CITY OF PORTLAND, MAINE

March 29, 2018

Project Name:	Parris Terraces	Project ID:	2017-287 and 2017-297 (IZ)
Address:	60 Parris Street	CBLs:	33-A-13
Applicant:	City of Portland		
Planner:	Nell Donaldson

Parris Terraces, 60 Parris Street
Level III Subdivision and Conditional Use Review
2017-287
Horton LLC

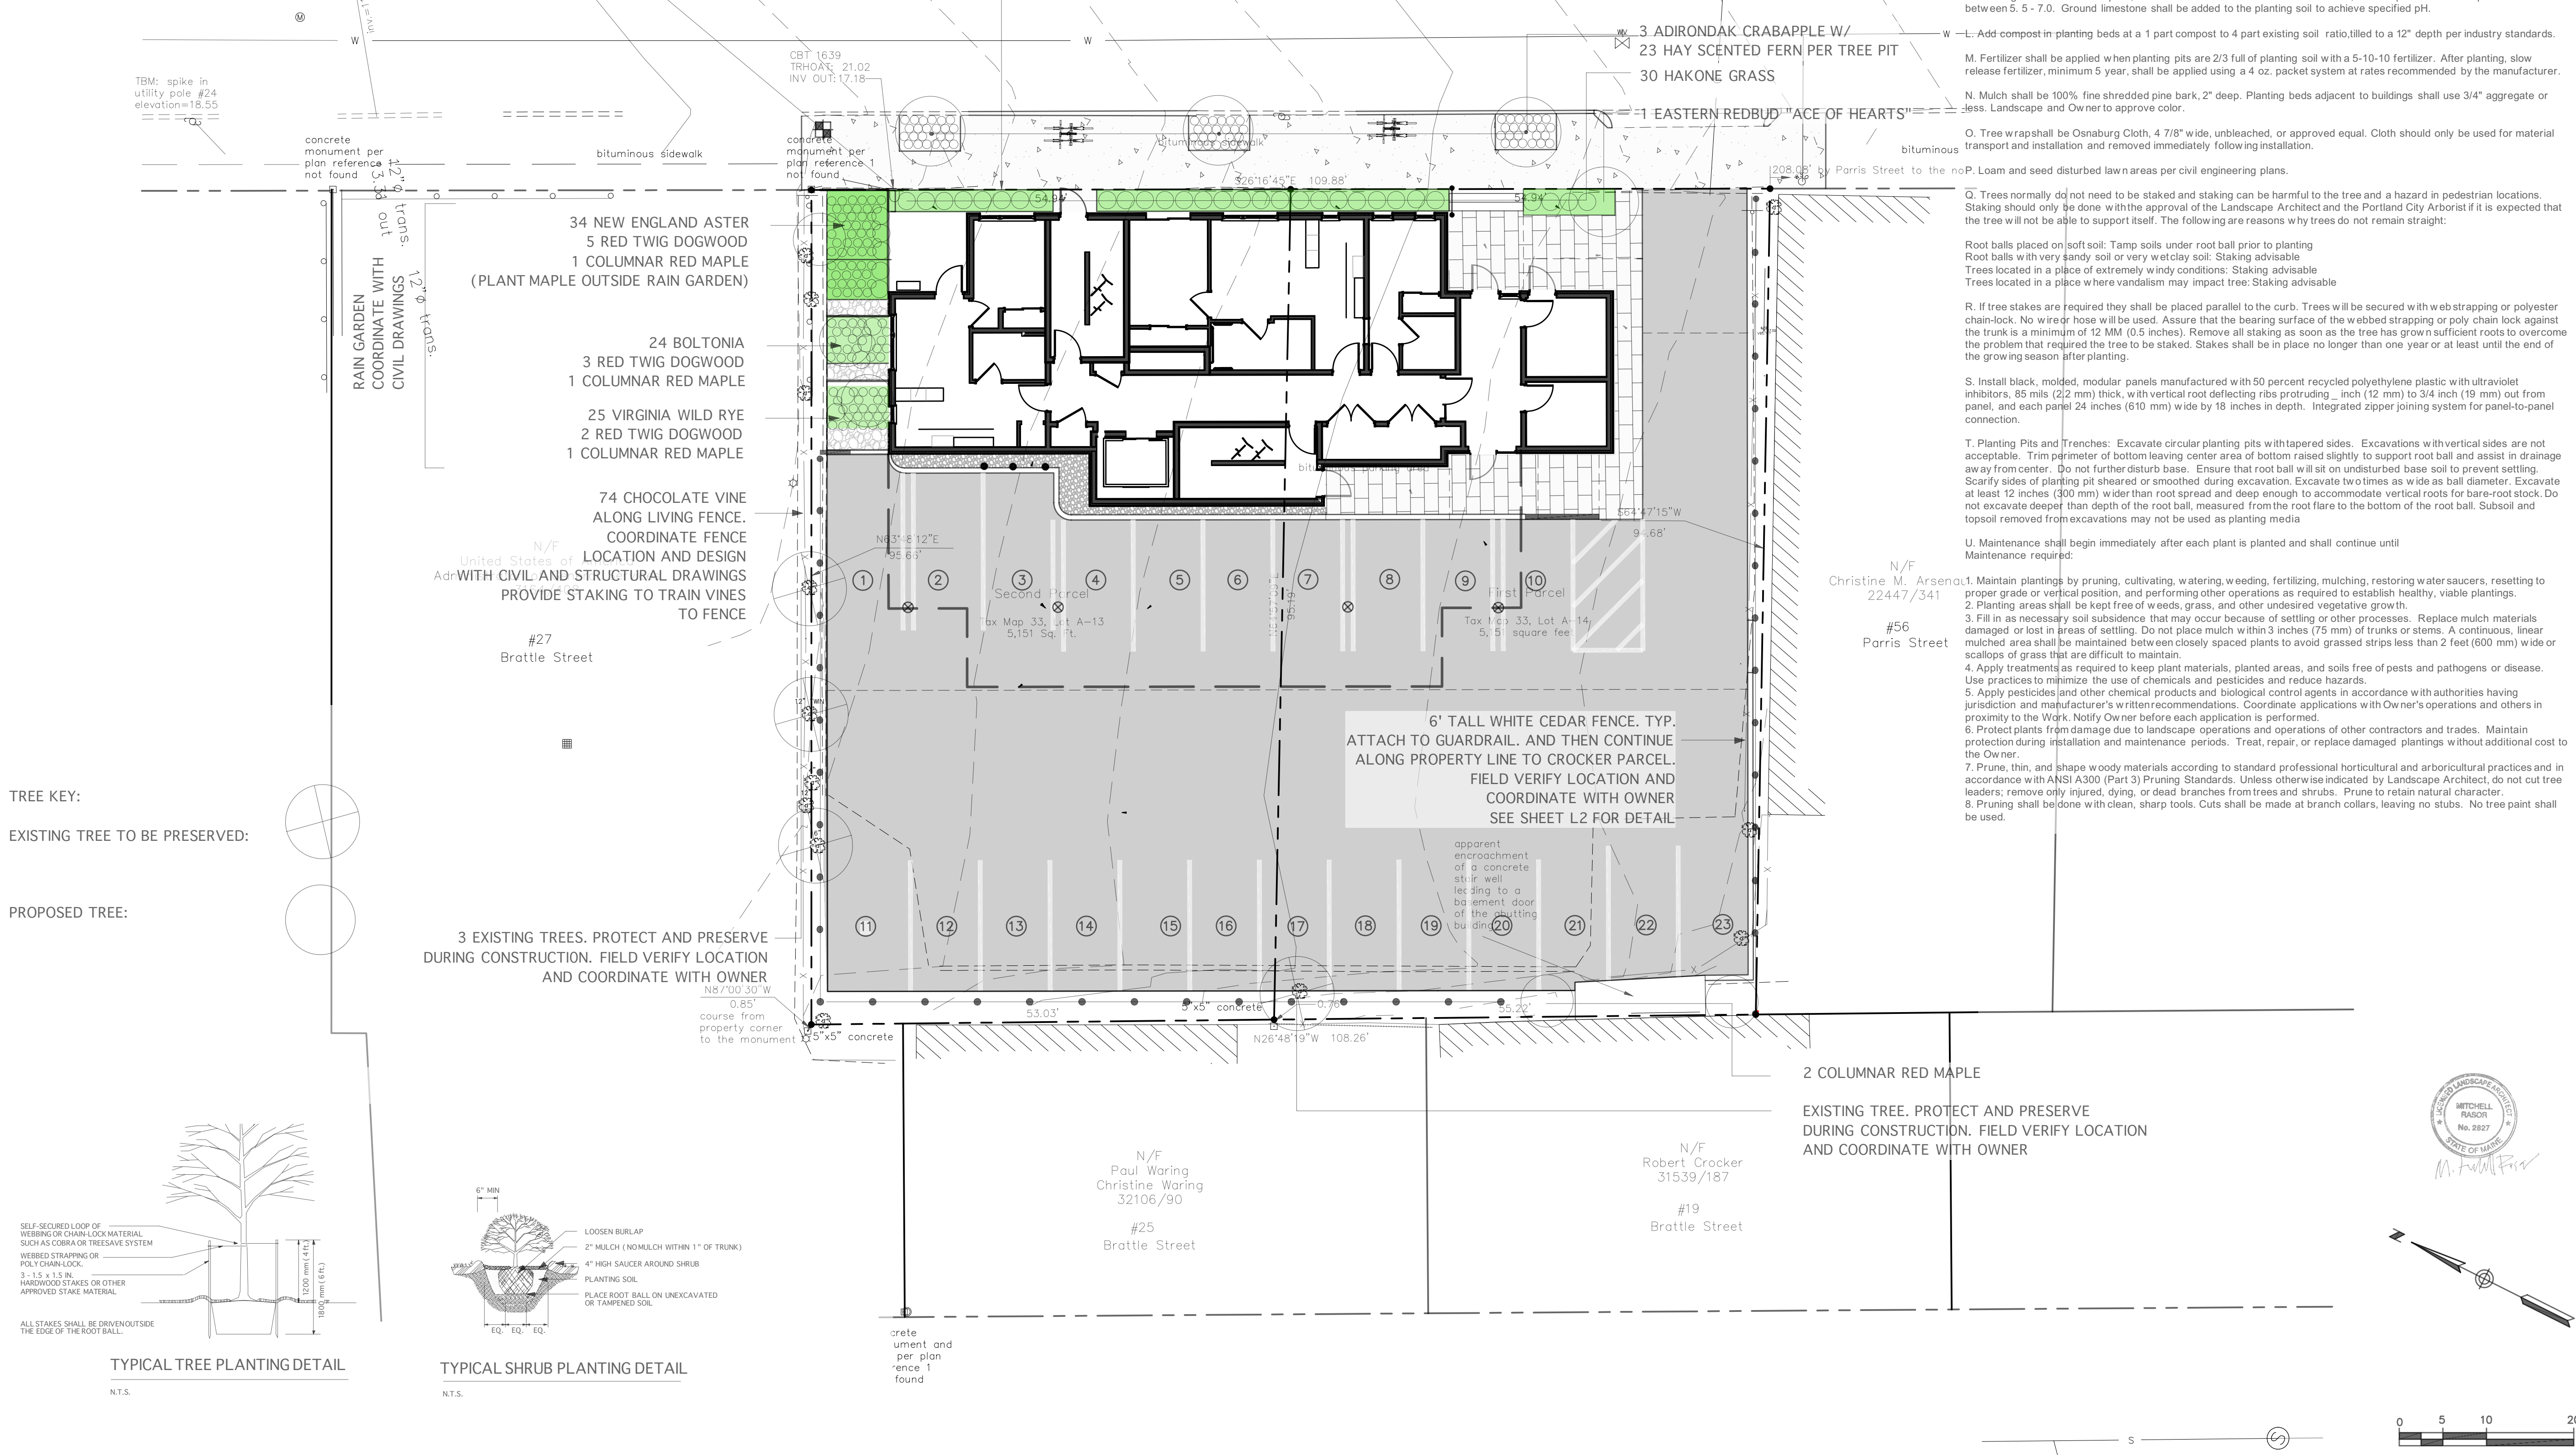
The proposed building footprint takes up a large percentage of the project site leaving minimal space for landscape treatment. Proposed tree & landscape features include three Sentry (upright) Ginkgo trees with Hay Scented Fern planted in the tree sidewalk, ornamental grasses planted near the building foundation along with Red-twig Dogwood. These are durable plants and should fare well in the landscape. Review comments, conditions might include: switching the proposed Ginkgo tree type to an ornamental scale tree type that can survive under the overhead utility lines to reduce future topping. Recommendations include: Adirondack Crabapple, Honeylocust, Accolade Cherry.

3. The applicant shall revise the street tree species as shown in the landscape plan for review and approval by the City Arborist;
4. The applicant shall revise the stormwater submittal to:
